Application by VPI Immingham B Limited for an Order Granting Development Consent for VPI Immingham OCGT Project

The Examining Authority's Written Questions and Requests for Information (ExA WQs)

Issued on Thursday 15 August 2019

Drawing Title
FIGURE 6.2: OPERATIONAL PROCESS CONTRIBUTION TO LONG-TERM NO₂

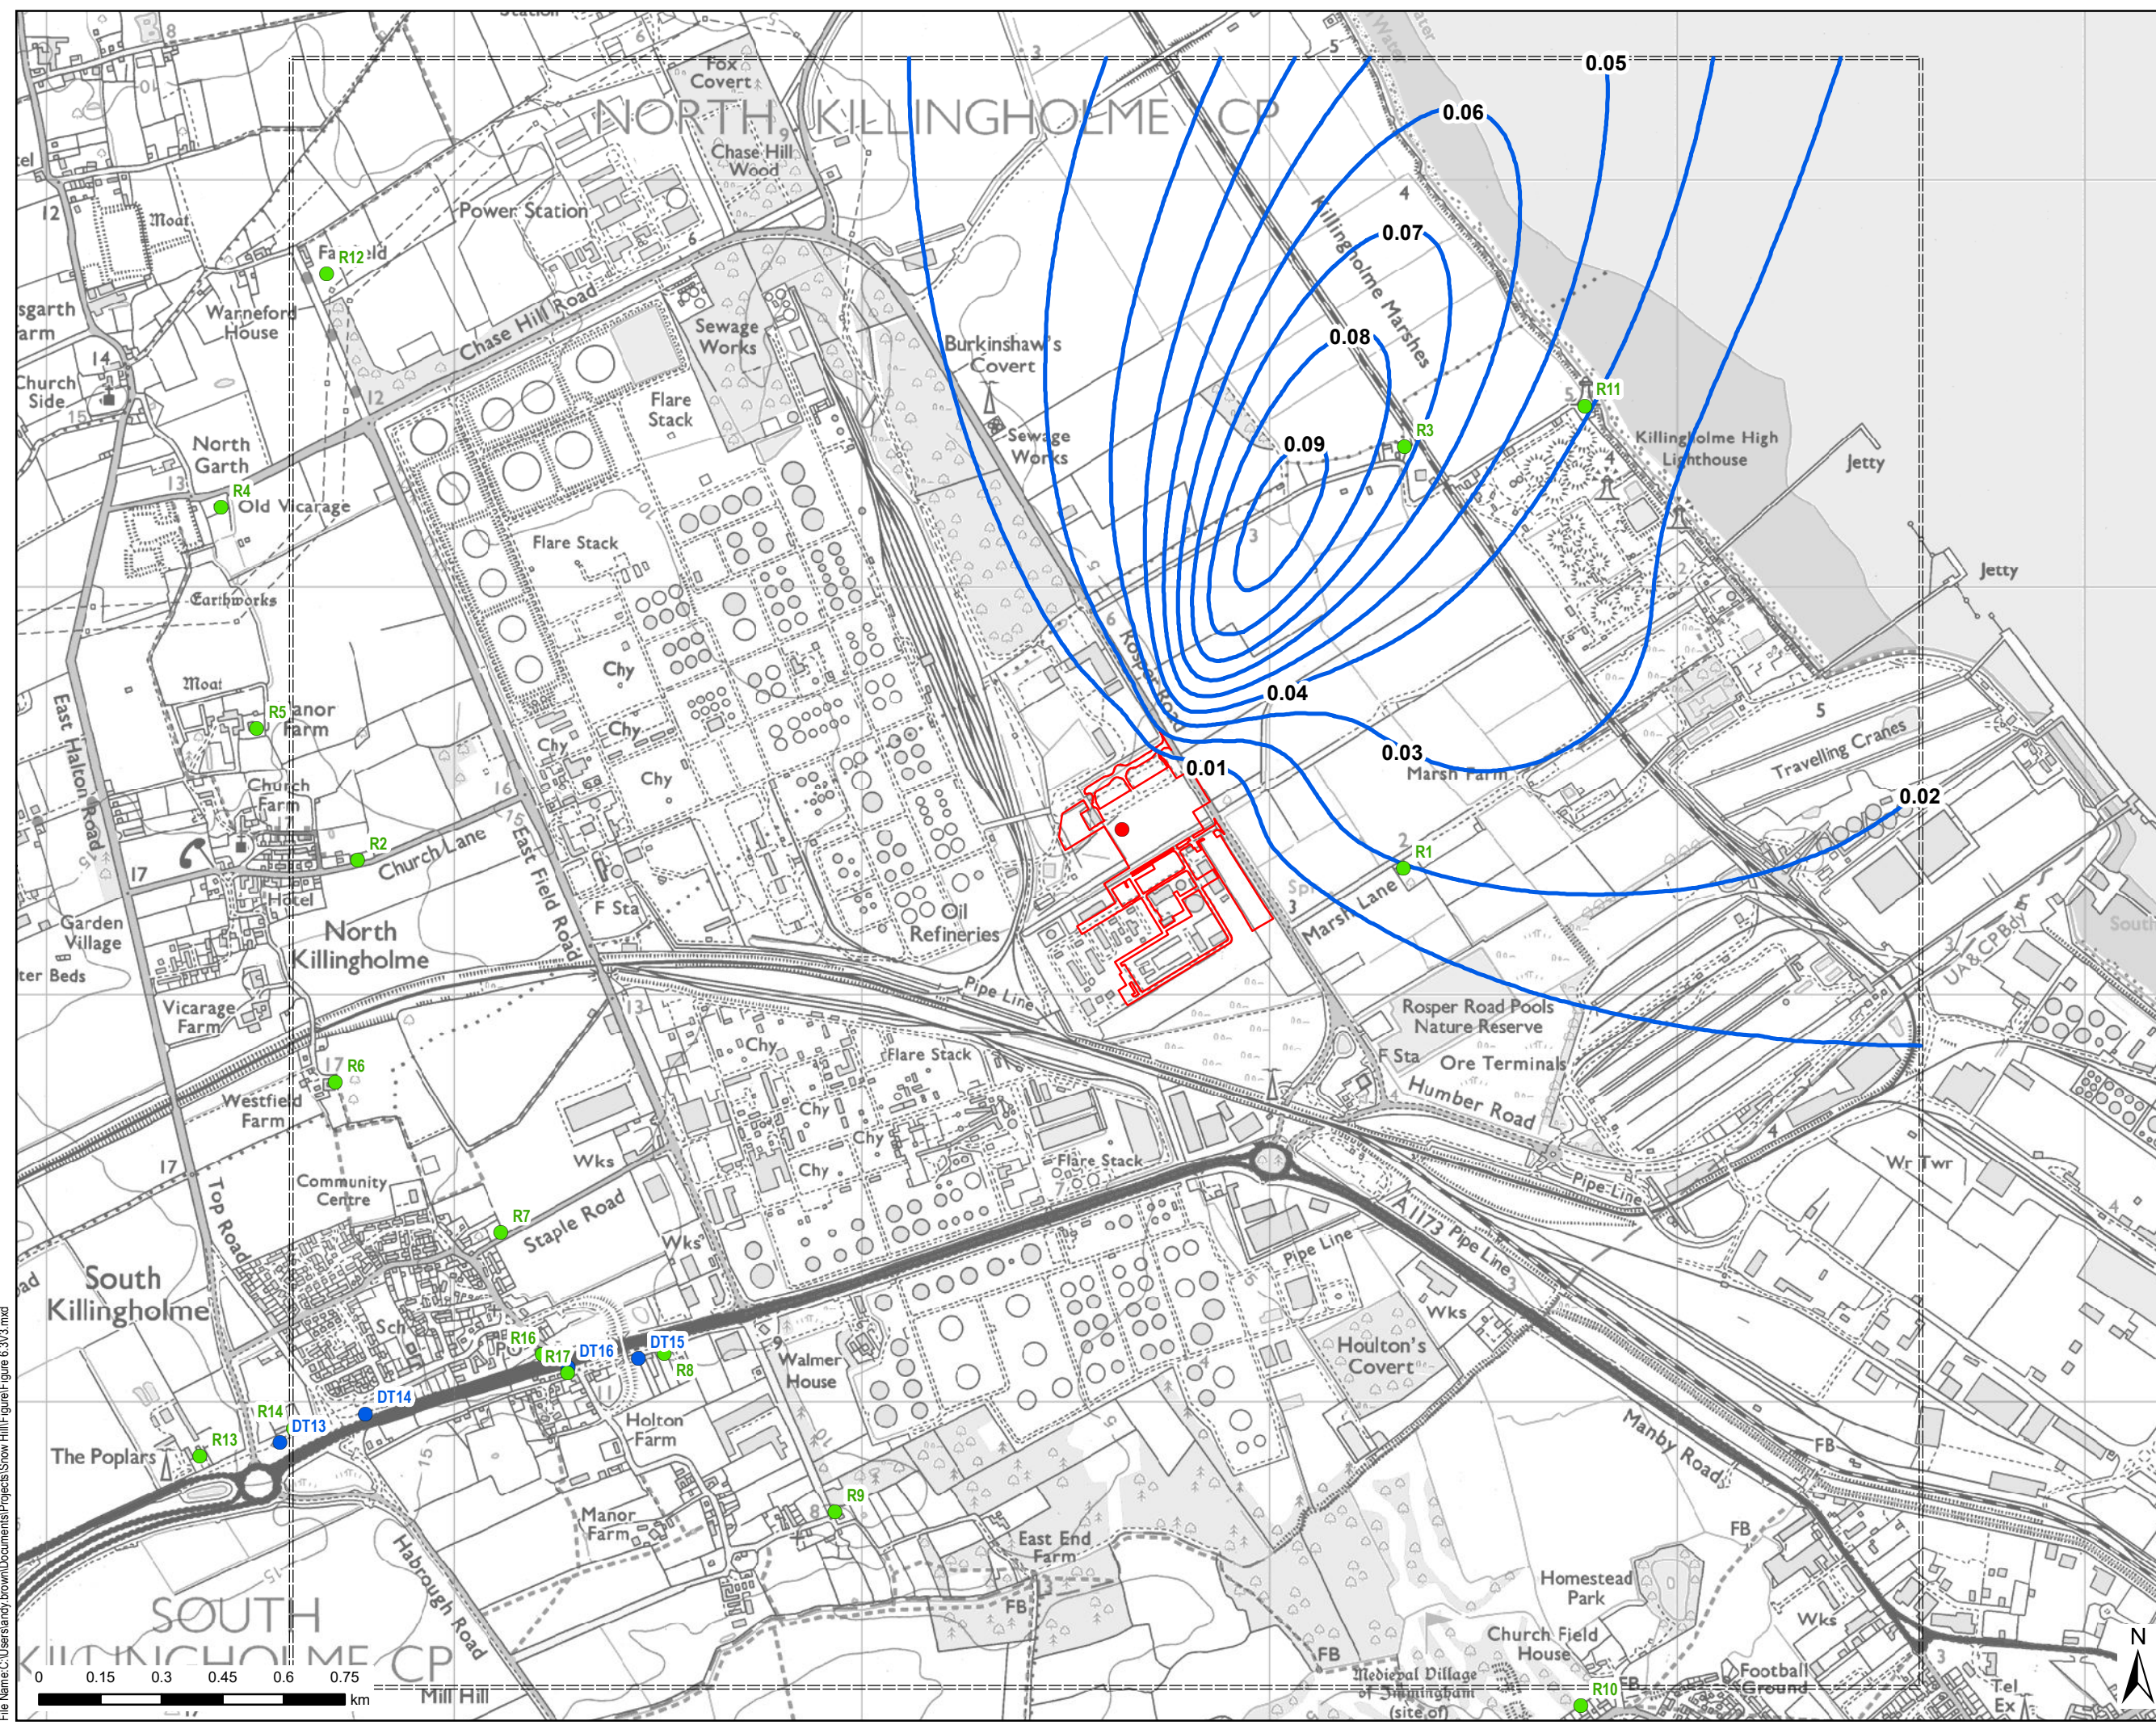
Q1.1.4	<i>Confidence of baseline Air Quality Data</i> Applicant	The locations of the NLC automatic NO ₂ monitoring stations are not depicted on Figure 6.2 [APP-057] and Figure 6.3 [APP-058]. The figures show the monitoring stations and diffusion tubes used to collect baseline data are not distributed throughout the assessment study area. This is not addressed within the Chapter and it is unclear how this data is are representative of the entire study area. Can the Applicant explain the confidence it has in the baseline air quality data presented for receptors east of Rosper Road? In responding to this question, the Applicant should address the absence of diffusion tube monitoring locations within 500m of the site entrance. The Applicant should address what appears to be an

Ref No.	Respondent:	Question:
		uneven distribution of monitoring locations and the extent to which this affects the findings in relation to NO2 and particulates.
Q1.1.5	<i>Assumptions in assessing effects from construction traffic</i> Applicant	Can the Applicant describe the assumptions applied in assessing effects from construction traffic within the air quality assessment? The Applicant's response should address issues such as the anticipated routes for construction traffic and the likely numbers based on the proposed construction programme.
Q1.1.6	<i>Monitoring of baseline conditions</i> Applicant	The ES states that a combination of both chemiluminescent and diffusion monitoring has been used to establish baseline air quality conditions. Can the Applicant explain the extent to which the techniques are compatible in this regard and whether there are limitations or assumptions that have been applied to address any incompatibility? If there are limitations, then how have these been addressed in the assessment of likely significant effects?

Q1.1.7	<i>Monitoring data</i> Applicant	ES Figure 6.2 [APP-057] and ES Figure 6.3 [APP-058] show that DT15 is the NO2 monitoring station closest to the site, but no reason has been provided for not using the data from DT15 monitoring station. Can the Applicant explain why diffusion tube DT15 and monitoring station DT13 were not used to establish the baseline conditions?
Q1.1.8	<i>Provisional 2018 data</i> Applicant	Chapter 6 of the ES [APP-035] makes reference in paragraphs 6.8.12 and 6.8.16 to provisional 2018 data for monitoring station CM9. Can the Applicant state the source of the provisional 2018 CM9 monitoring station data and state whether the resultant data has been verified by the appropriate professional body?
Q1.1.9	<i>Traffic Construction Assessment 2021</i>	The construction traffic assessment 2021 baseline includes forecast models that

Drawing Title
ZONE OF THEORETICAL VISIBILITY FIGURE 10.1

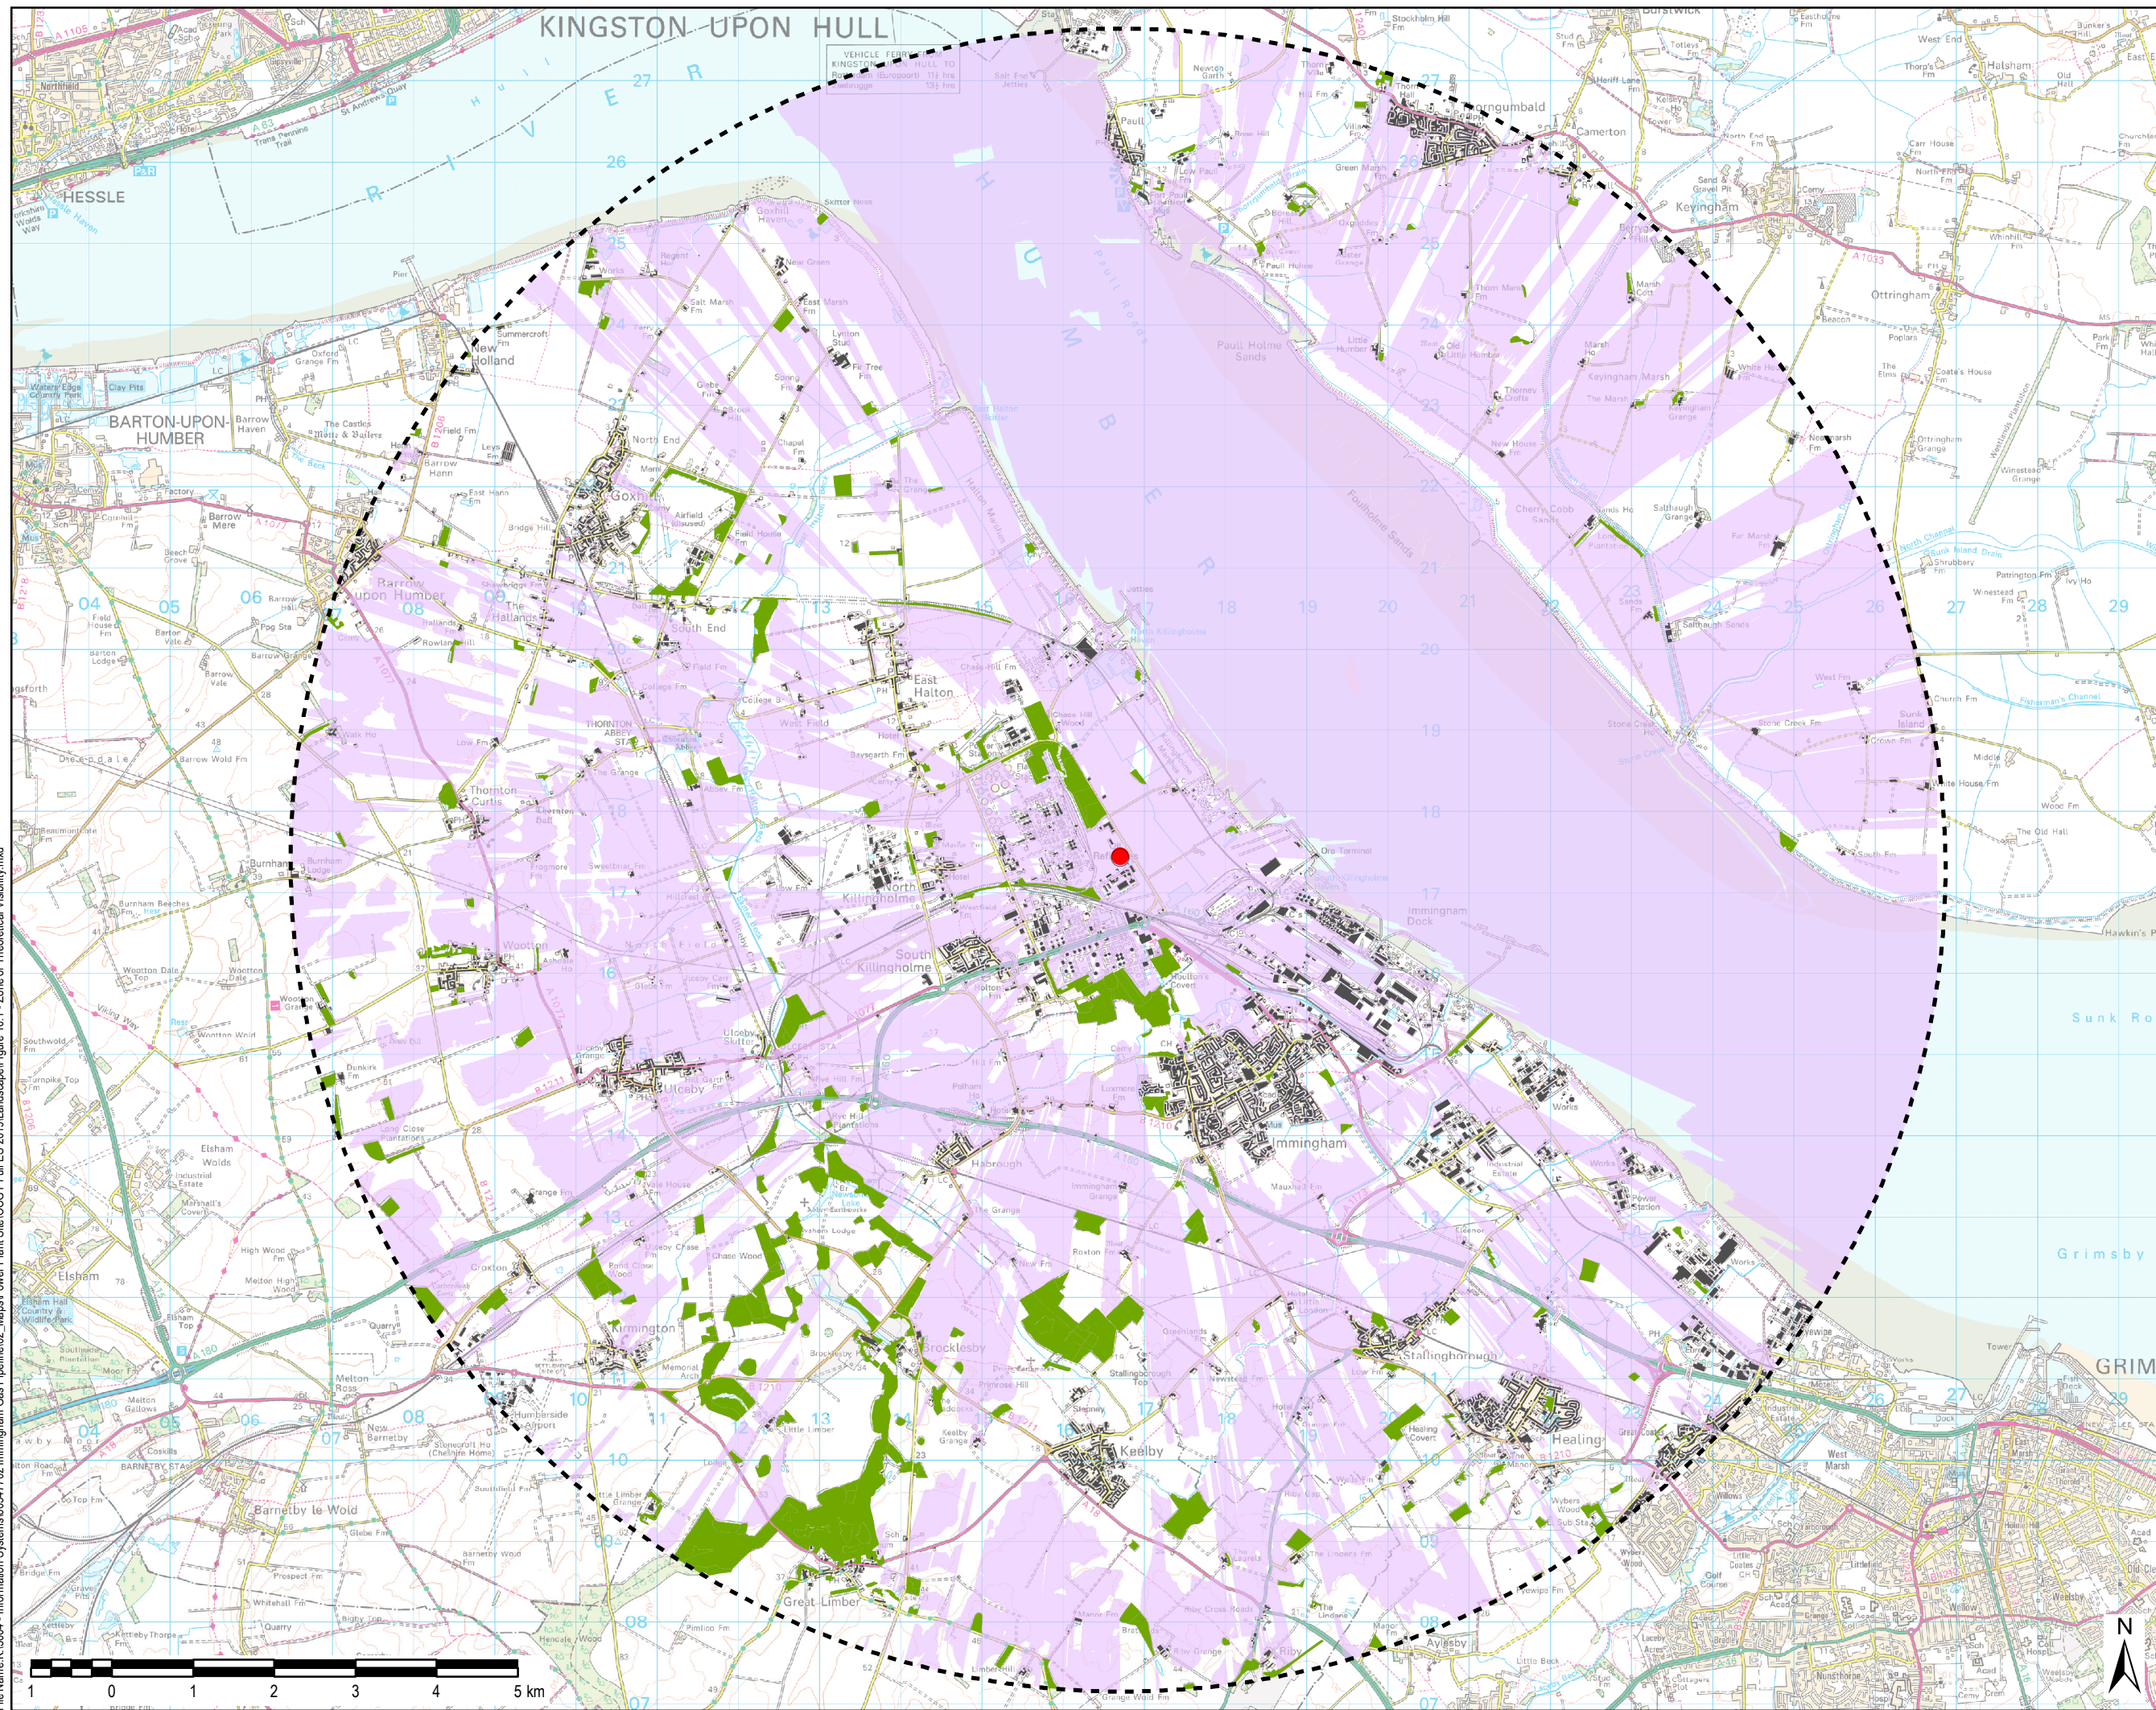
Q1.7.3	<i>Extent of study area</i> Applicant	Please clarify the extent of the study areas for designated and non-designated heritage assets. Please explain why a smaller area of study was used for non-designated assets. Please explain how the above study areas relate to the Zone of Theoretical Visibility (ES Figure 10.1 [APP-062]).
Q1.7.4	<i>Brocklesby Park/ Pelham Pillar</i> Applicant	Please comment on the concerns raised by West Lindsey District Council as part of their Relevant Representation [RR- 016] in relation to Brocklesby Park and the relationship with Pelham Pillar at Cabourne High Wood. Please explain how this has been taken into account in assessing the impact on
